From: Michael Eastham <Michael.Eastham@arun.gov.uk>
Sent: 12 March 2020 23:00
To: Planning.Responses <Planning.Responses@arun.gov.uk>
Subject: FW: BE/15/20/DOC Full Condition 44

Have you reached a decision on Full condition 44, regarding the detail of the northern bund?

PHASE 2 EXTERNAL LEVELS
FOR DOC 10 & 45

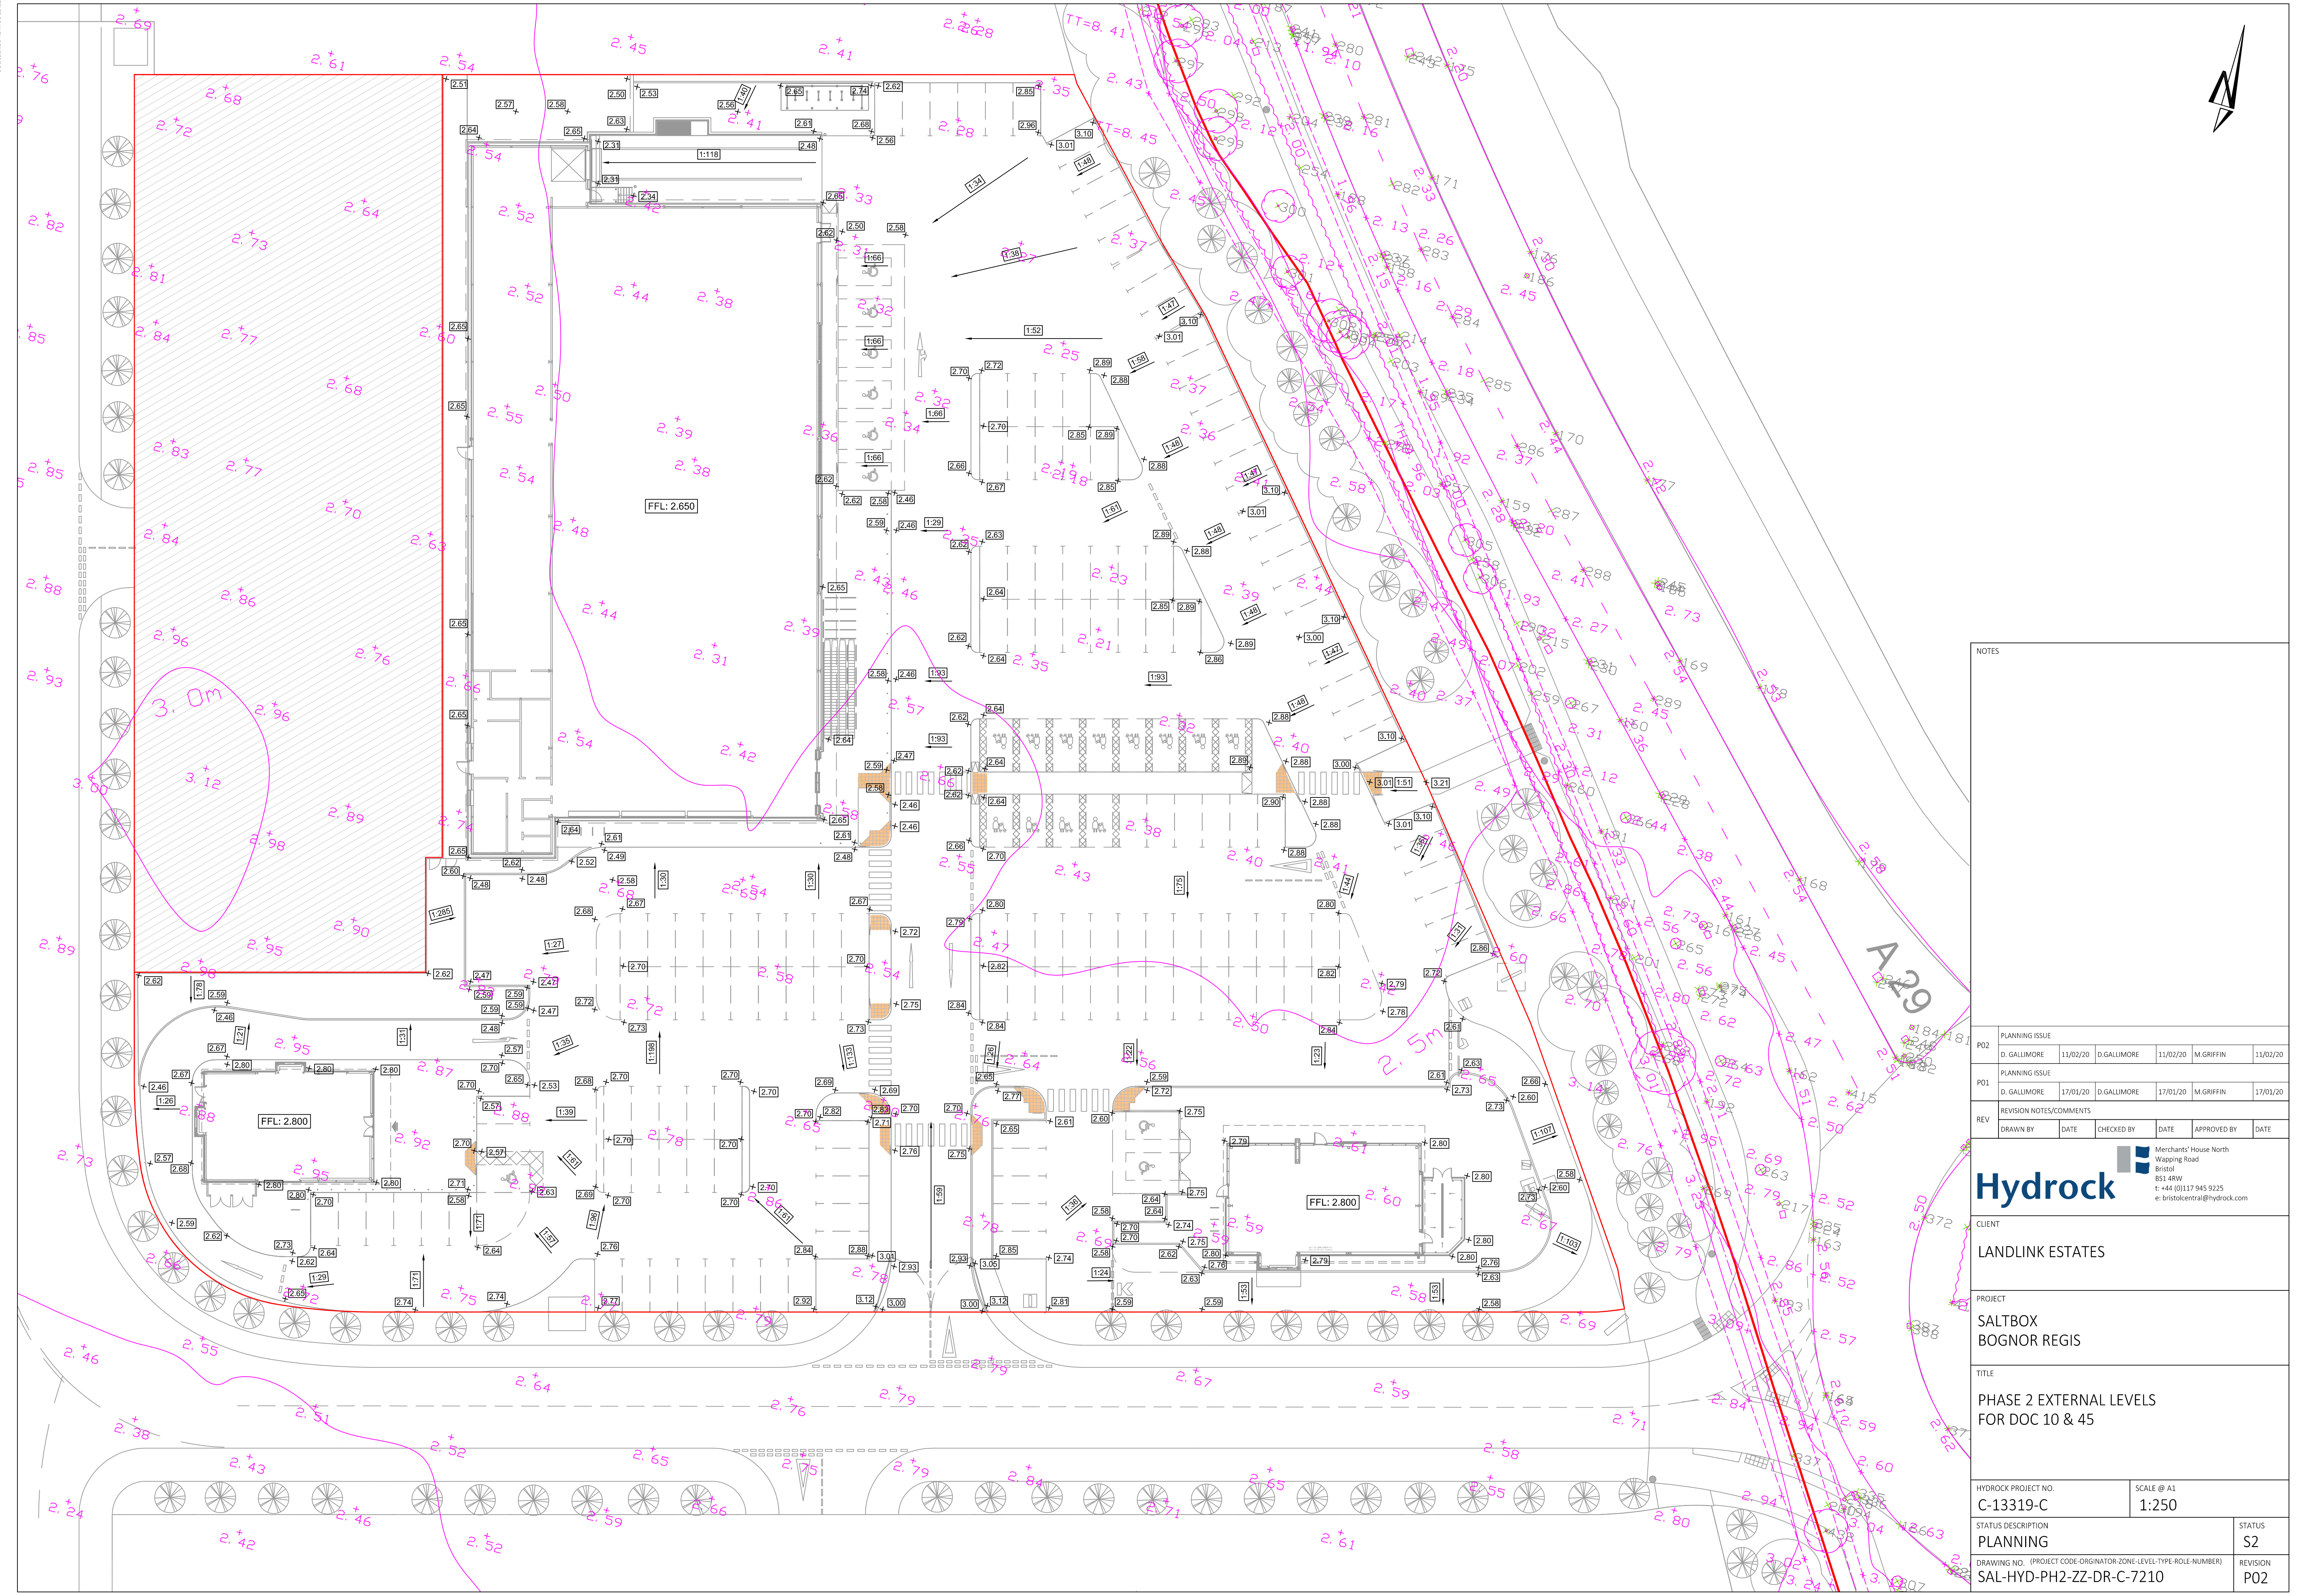
The bund itself looks fine.

I am a little concerned about the drainage ditch – a) is it shown in principle? And b) what are the arrangements for its discharge (to the westerly ditch or into your system)? I don't think it is as showstopper, I'd just like to know how it fits into the bigger picture.

Also the north side of the ditch would seem to be right on the 'red line' of your site.

The drainage ditch shown along the northern edge of the site is existing, and we don't plant to change how this runs or where it discharges.

The red line for the site is to the northern side of the ditch. The bund is held back 5m from the southern side of the ditch to allow access for maintenance of the ditch.
